**STERLING RANCH DRAINAGE  
COST AND FEE ANALYSIS**

**January 18, 2021  
Project No. 25188.02  
SP-20-003**

**Prepared By:  
JR Engineering, LLC  
5475 Tech Center Drive, Suite 235  
Colorado Springs, CO 80919  
719-593-2593**

DBPS CHANNEL IMPROVEMENTS SEGMENT NO.

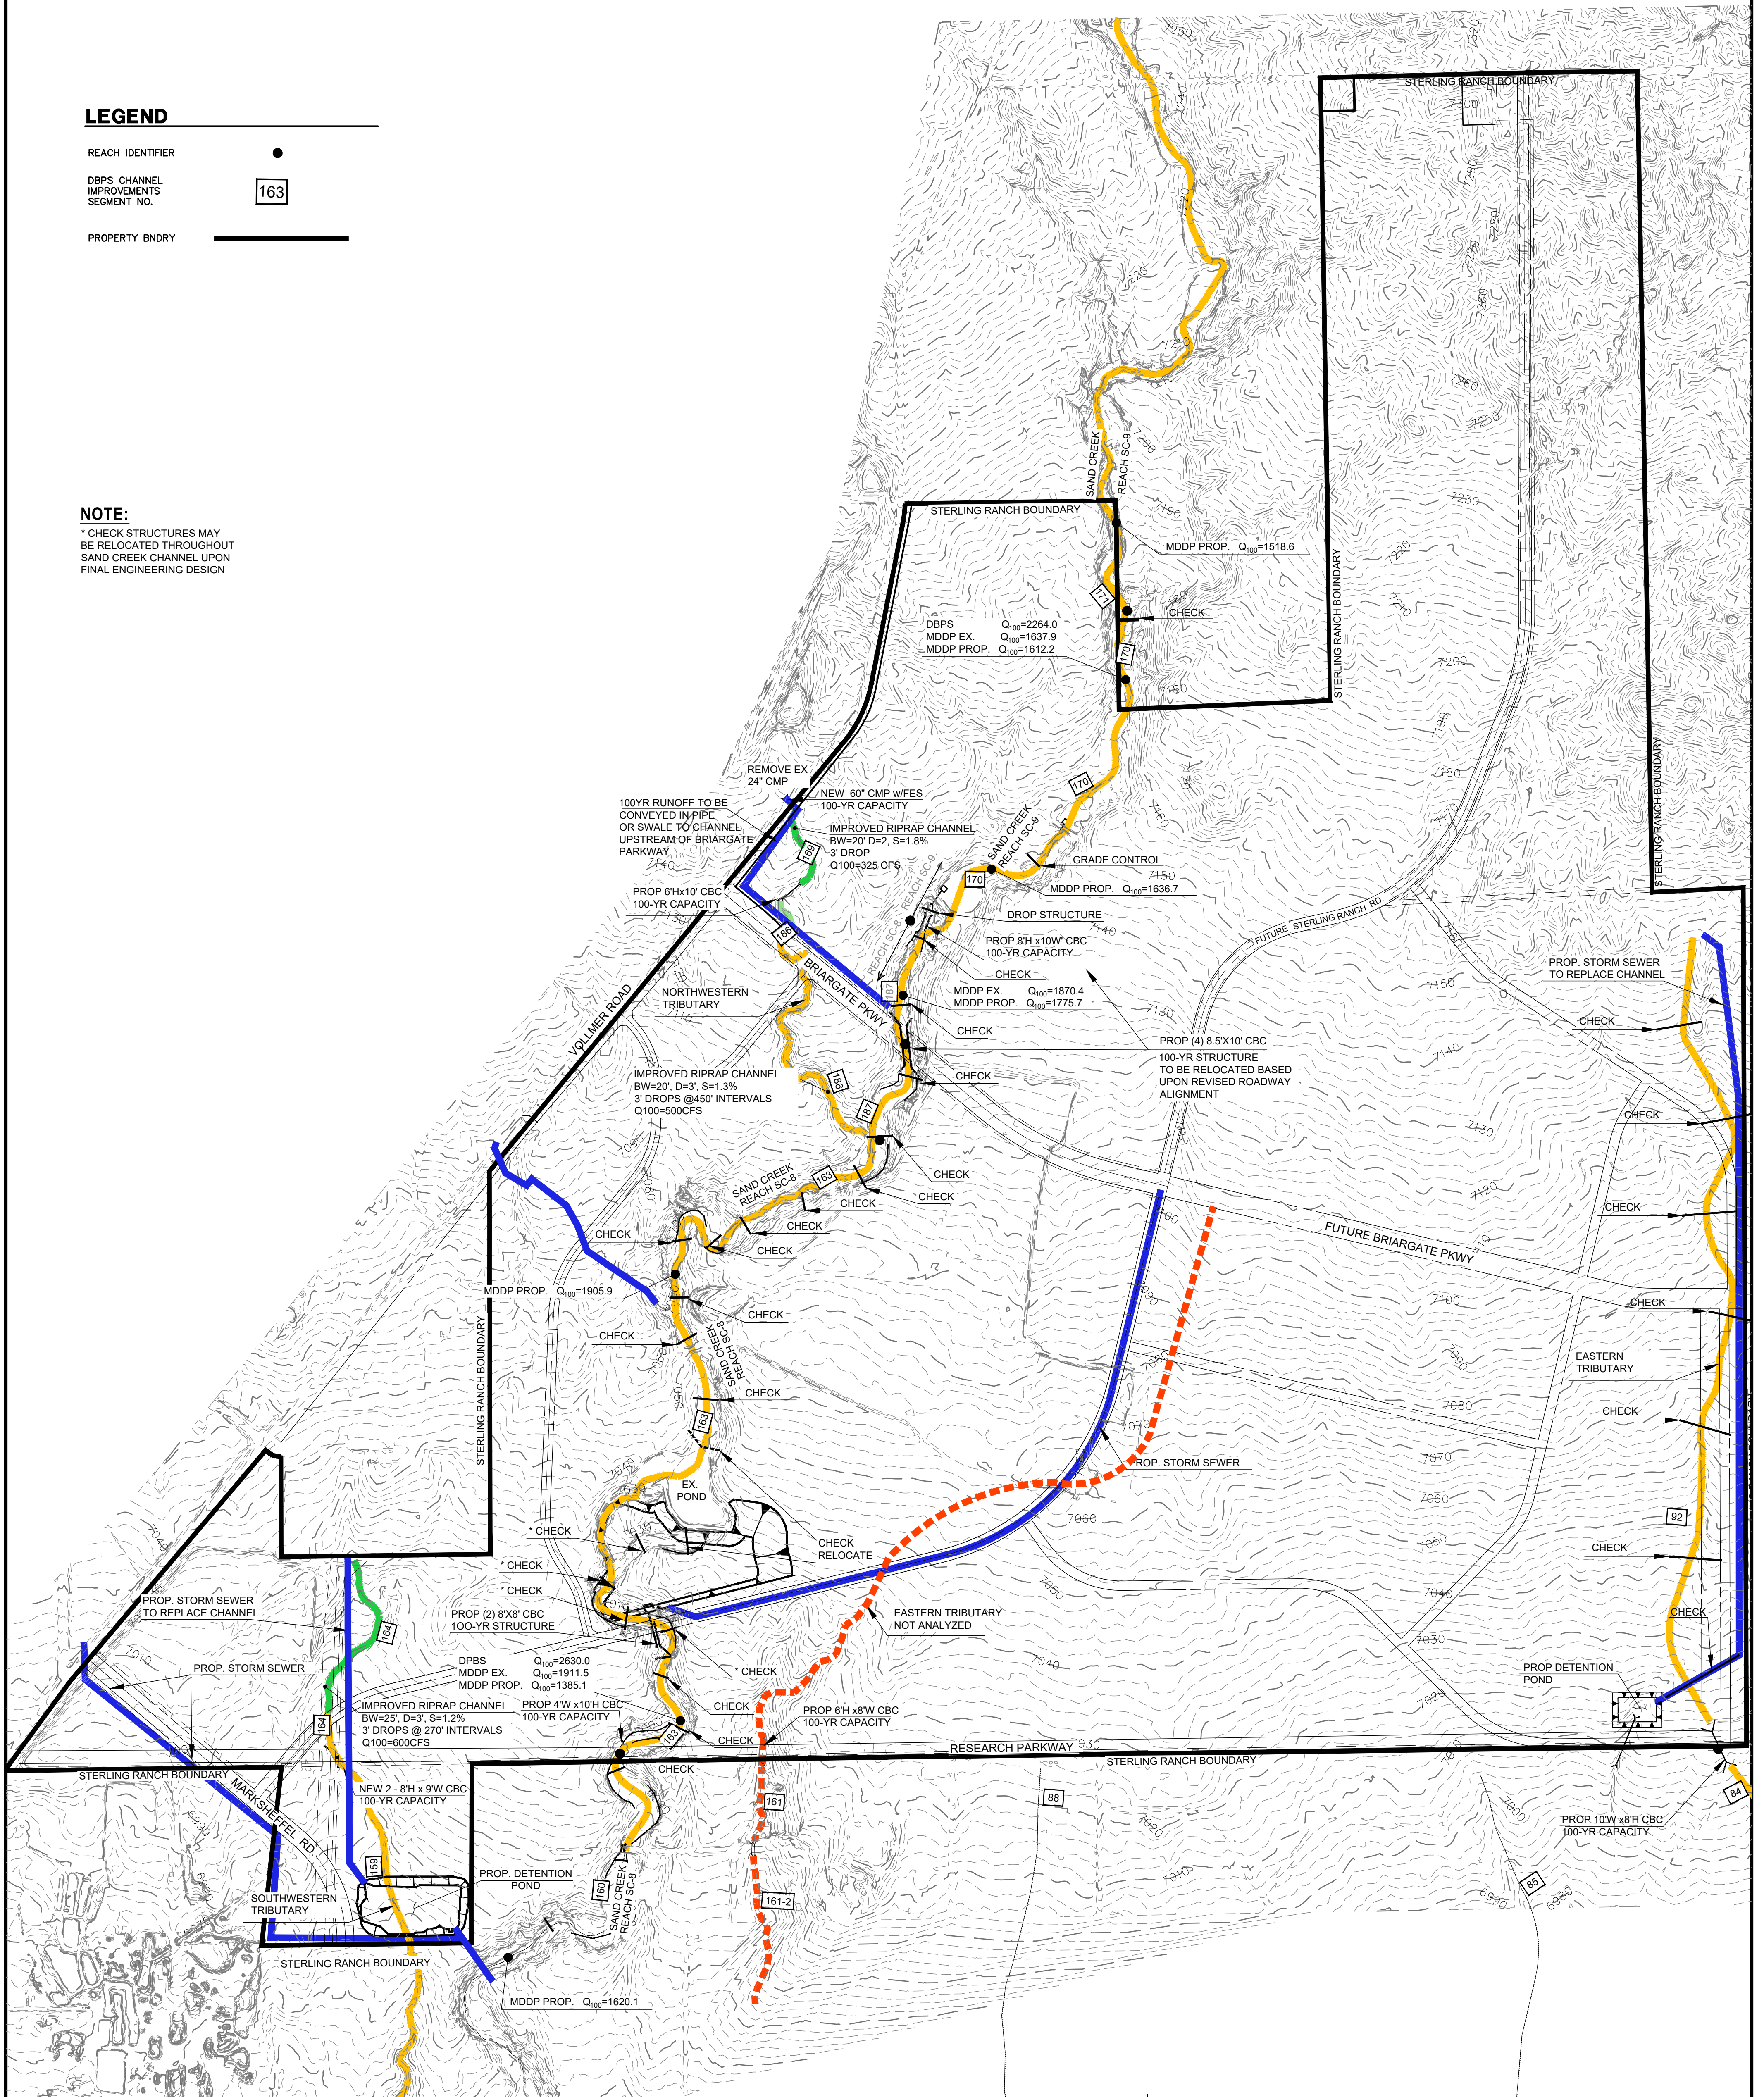
provide key number  
or symbol on map
